Our Ref: 15756
DPE Ref: SSDA 7317 MOD 5

SSDA 7317 MOD 5 – RESPONSE TO SUBMISSIONS

This Response to Submissions (RTS) letter is submitted to the Department of Planning & Environment (the Department) in support of Modification 5 to amend State Significant Development (SSD) consent SSD 7317 relating to the construction of a commercial campus at the Australian Technology Park, Eveleigh.

Drawing Title
BUILDING 2 - TRAVELATOR PLAN & SECTIONS

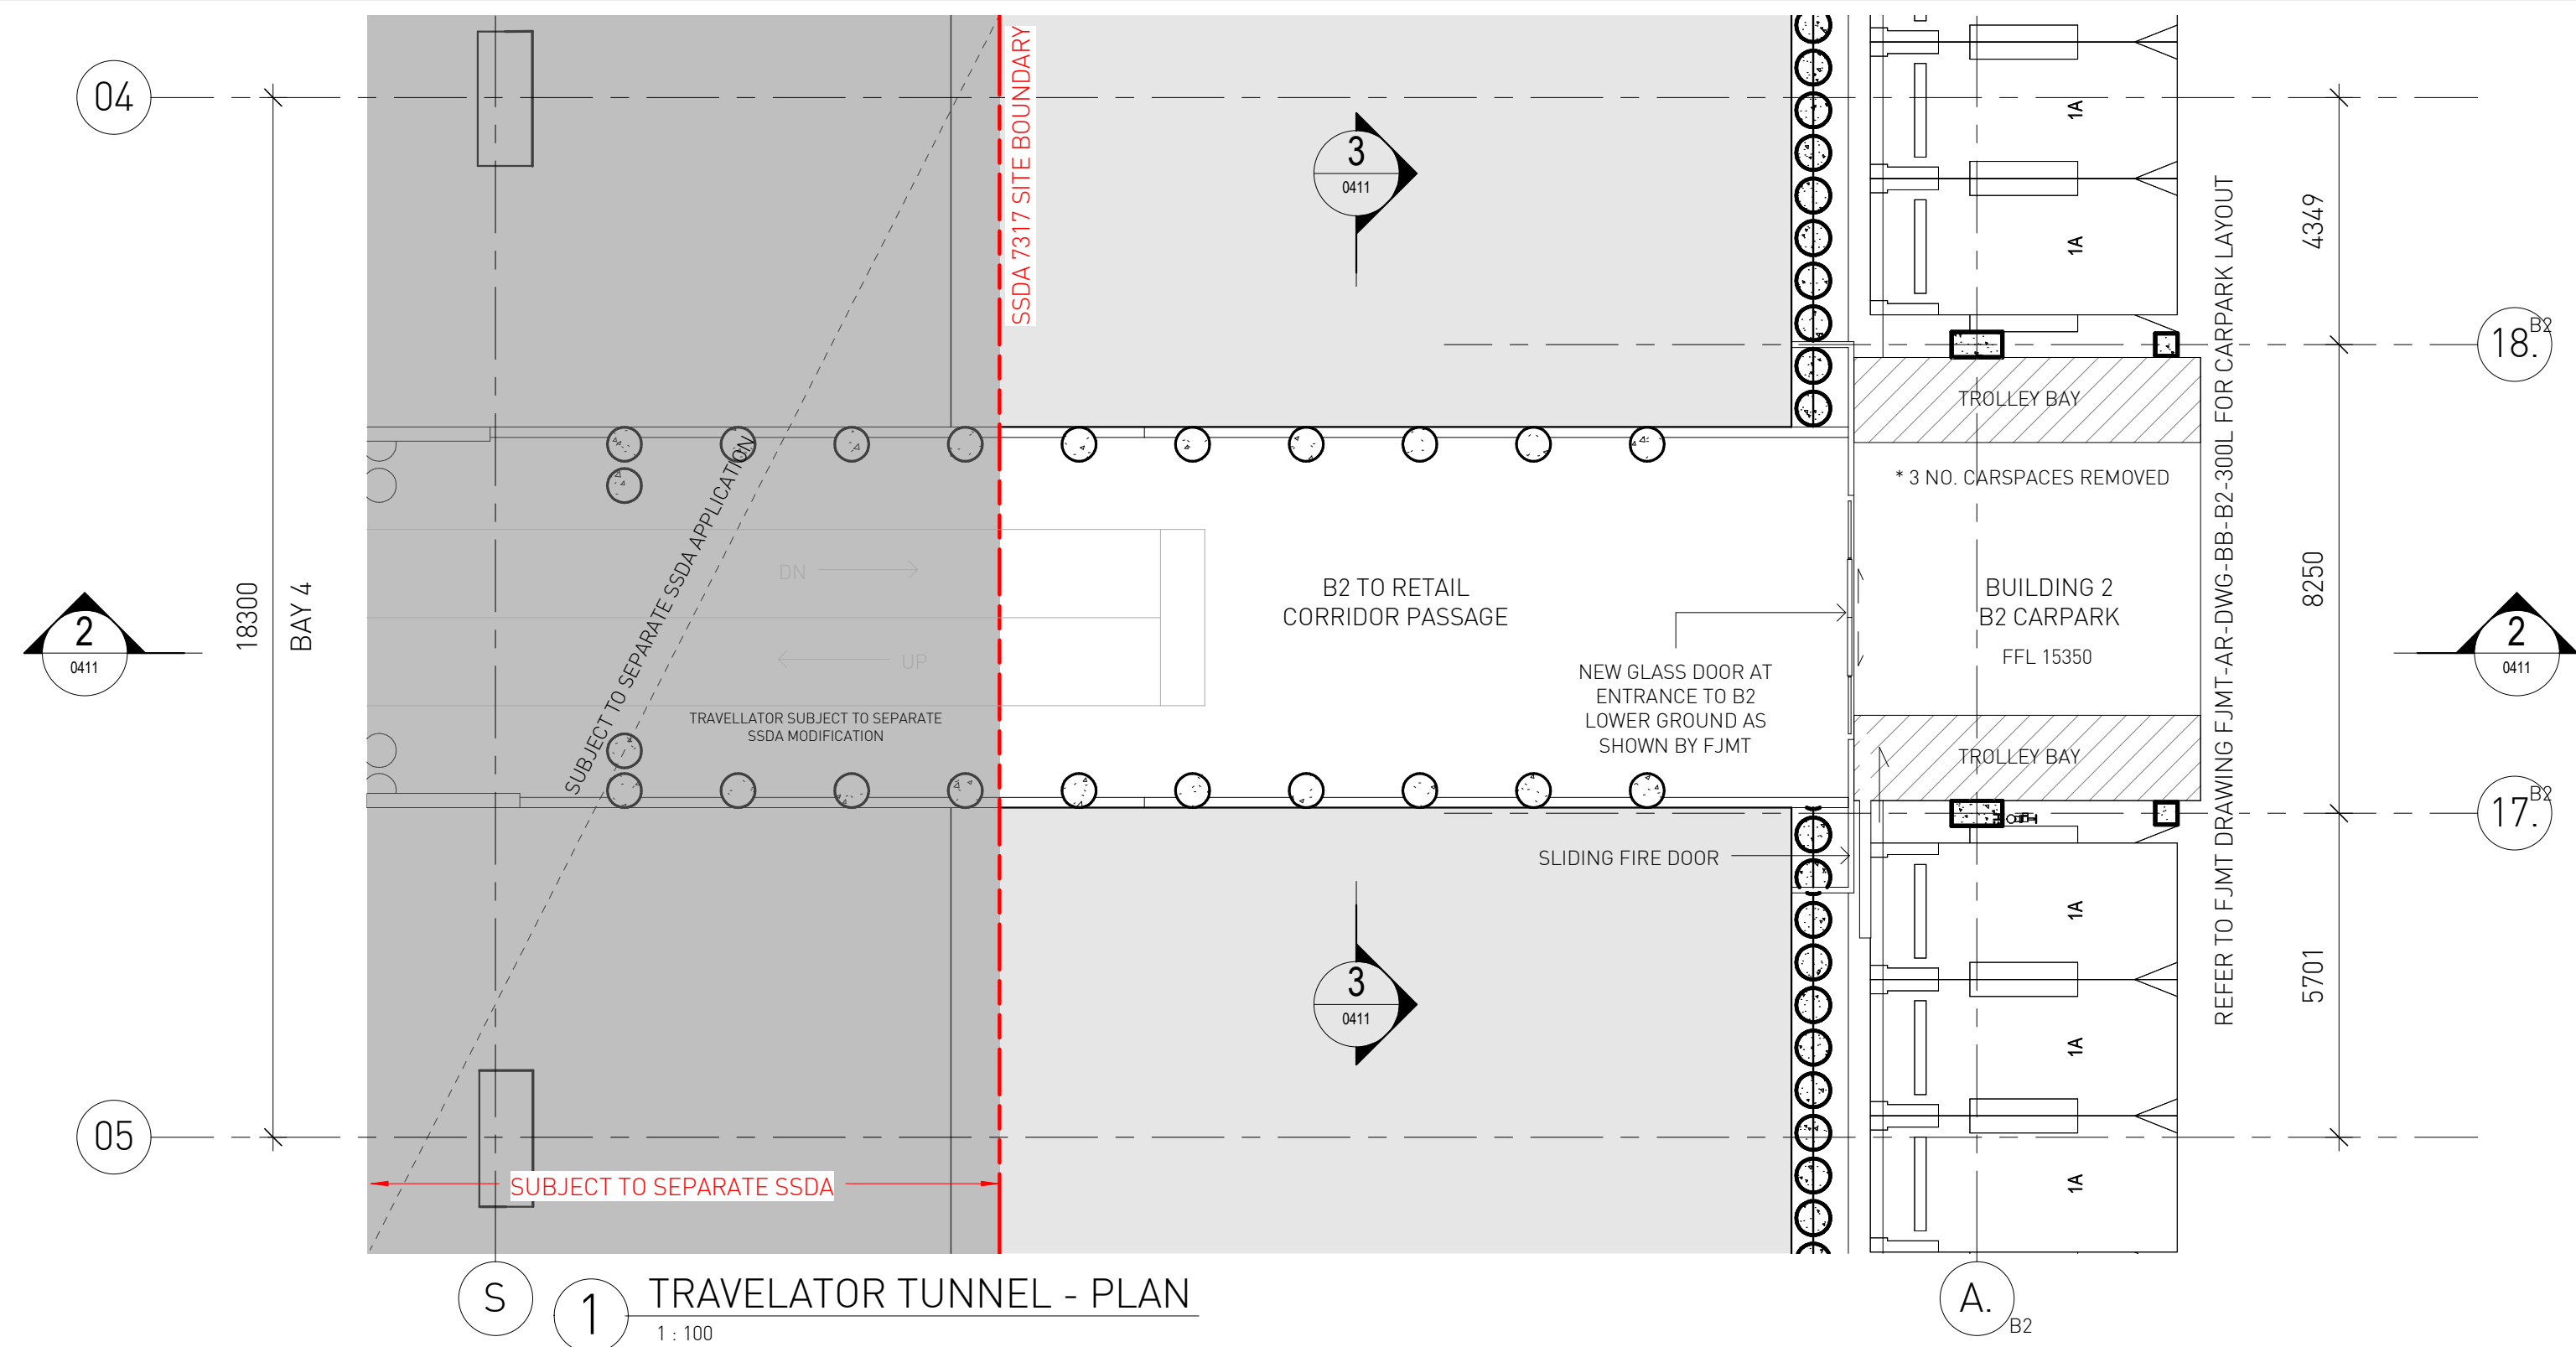
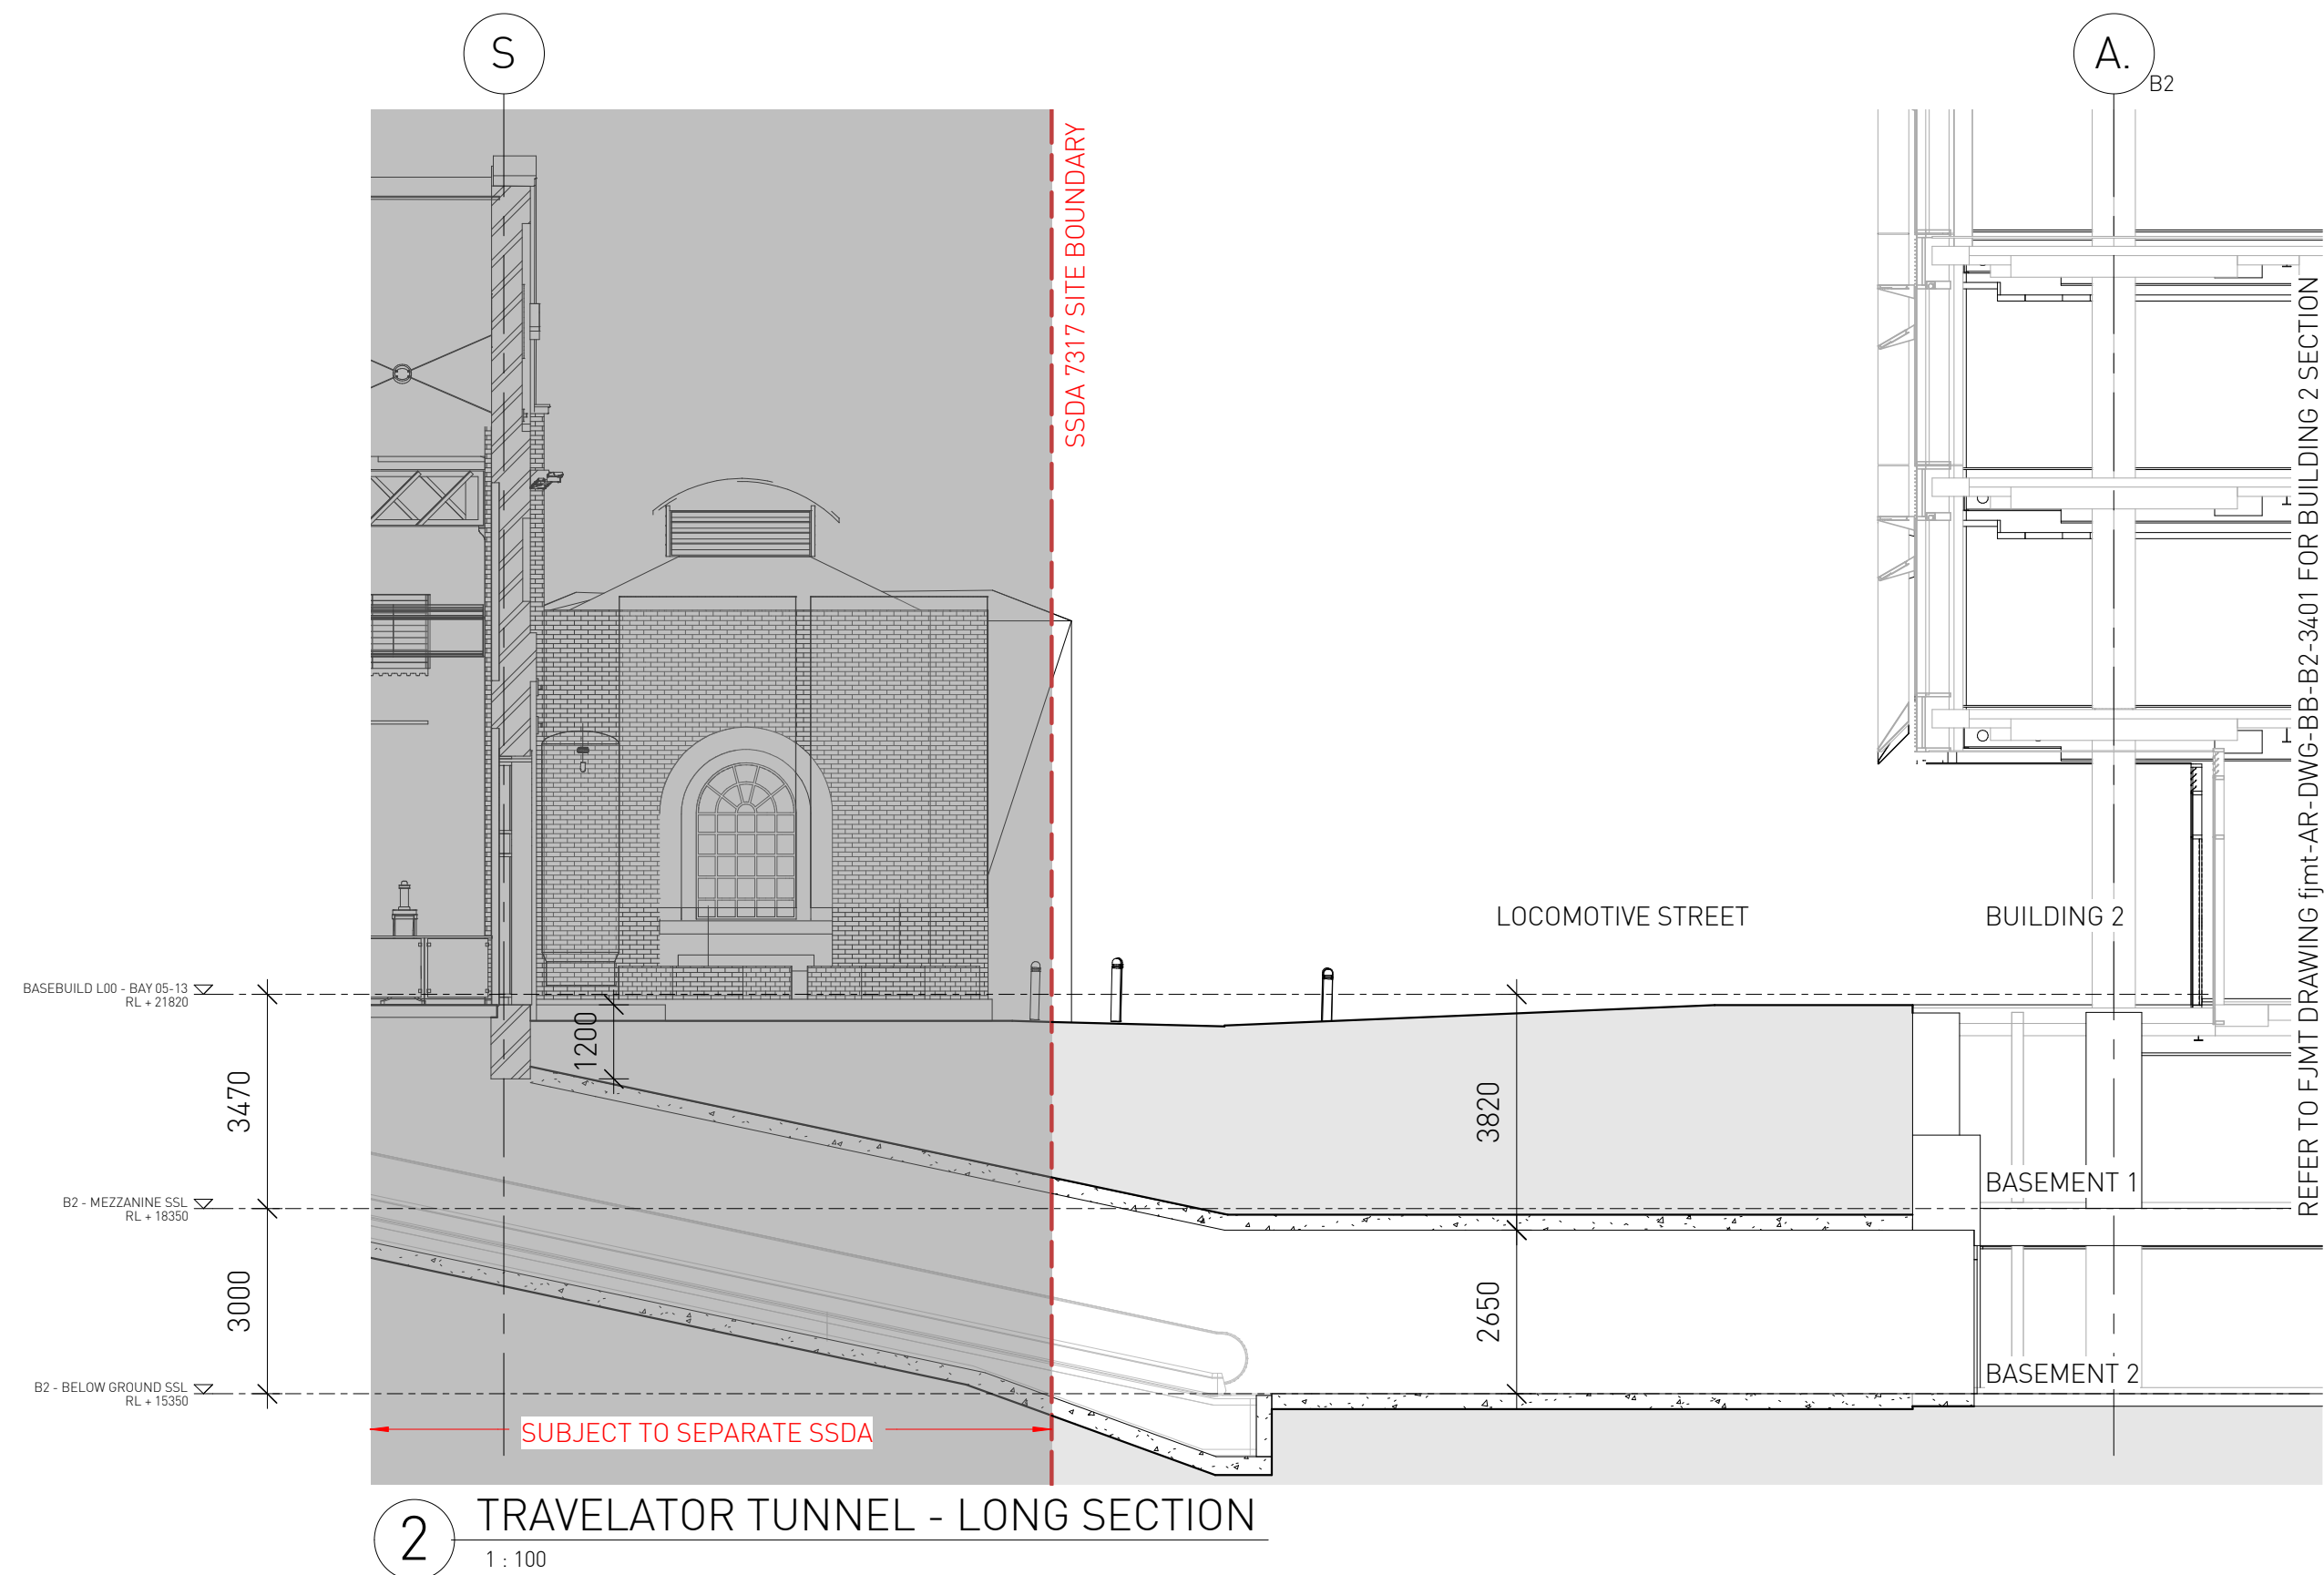
Provide justification for the need for the concrete base structure to be considered separately to SSD 8517, including details on the timing of the public domain works in Locomotive Street (SSD 7317) and future works associated with SSD 8517 if approved.

Provide plans/ details to demonstrate how the concrete base structure will be capped at the boundary between SSD 7317 MOD 5 and SSD 8517 as well as any interim works at the junction to the Building 2 basement.

During the construction works and until such time that the travelator is fully functional, the concrete base structure will be capped at the boundary between SSDA 7317 and SSD 8517 by hoardings and hoardings will also be used at the junction of Building 2.
